## DECISION DELEGATED TO HEAD OF PLANNING

**Application No:** H02-0849-23      **Applicant:** Mr L Johnson

**Proposal:** Demolition of existing garage and erection of new dwelling - retrospective - re-submission following appeal decision APP/A2525/W/22/3308445

**Location:** Adj. 26 West Bank Crowland Peterborough

MATERIAL PALETTE

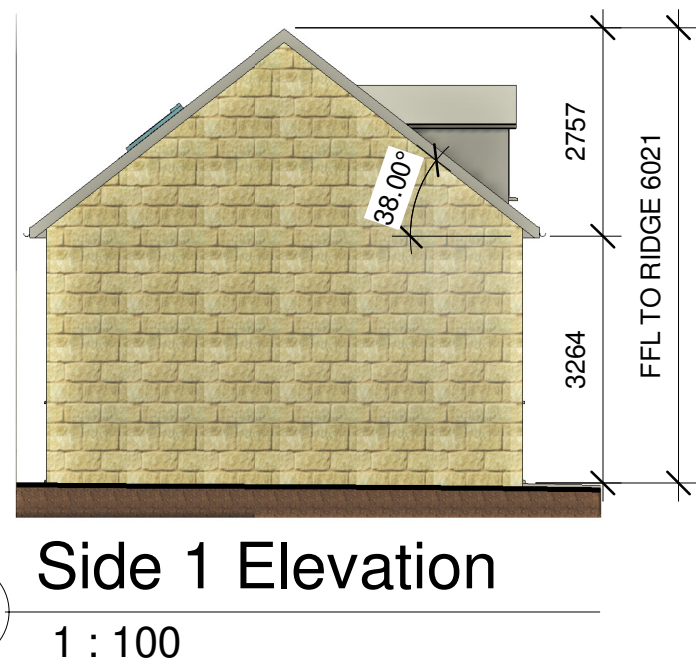
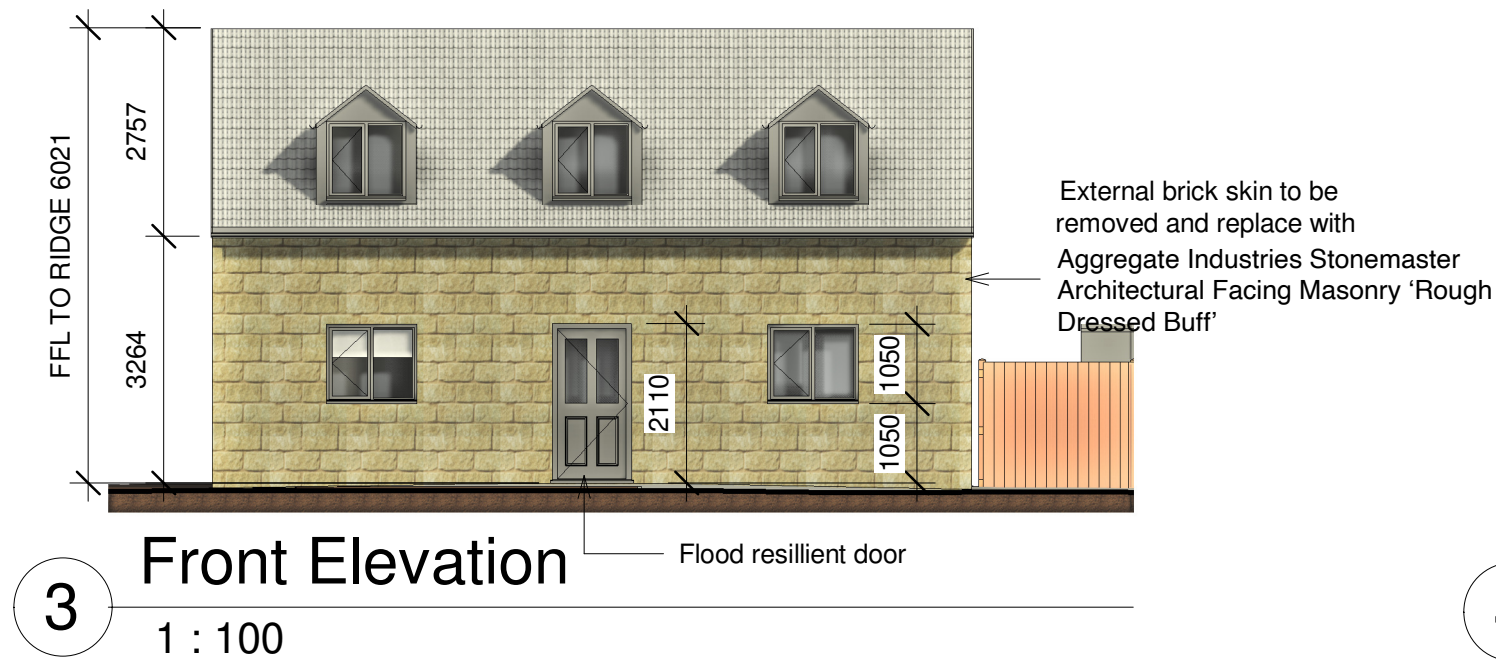
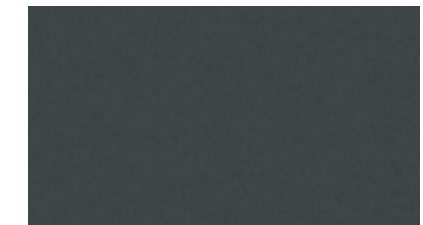
The applicant has provided a proposed elevations plan which shows that the external brick skin will be removed and replaced with 'aggregate industries stonemaster facing masonry 'rough dressed buff' which is of a more greyish appearance. At present they are Bradstone Marshlite Rustic Walling in Buff The plans also show that a new door will be inserted (replacing the white door) that would correspond with the colour of the openings. This approach, giving weight to the inspectors report is considered acceptable. A condition will be applied that within 3 months from the date of the permission the existing facing materials shall be replaced with the proposed facing materials including door shall. The materials shall be retained thereafter.

Comments have been made regarding the roof tile in that it is not in-keeping. The area has a double pan concrete interlocking tile at present, this is a dark material. The proposal offers a slate like appearance, this is considered appropriate in this instance as it sits well against the proposed gable dormers
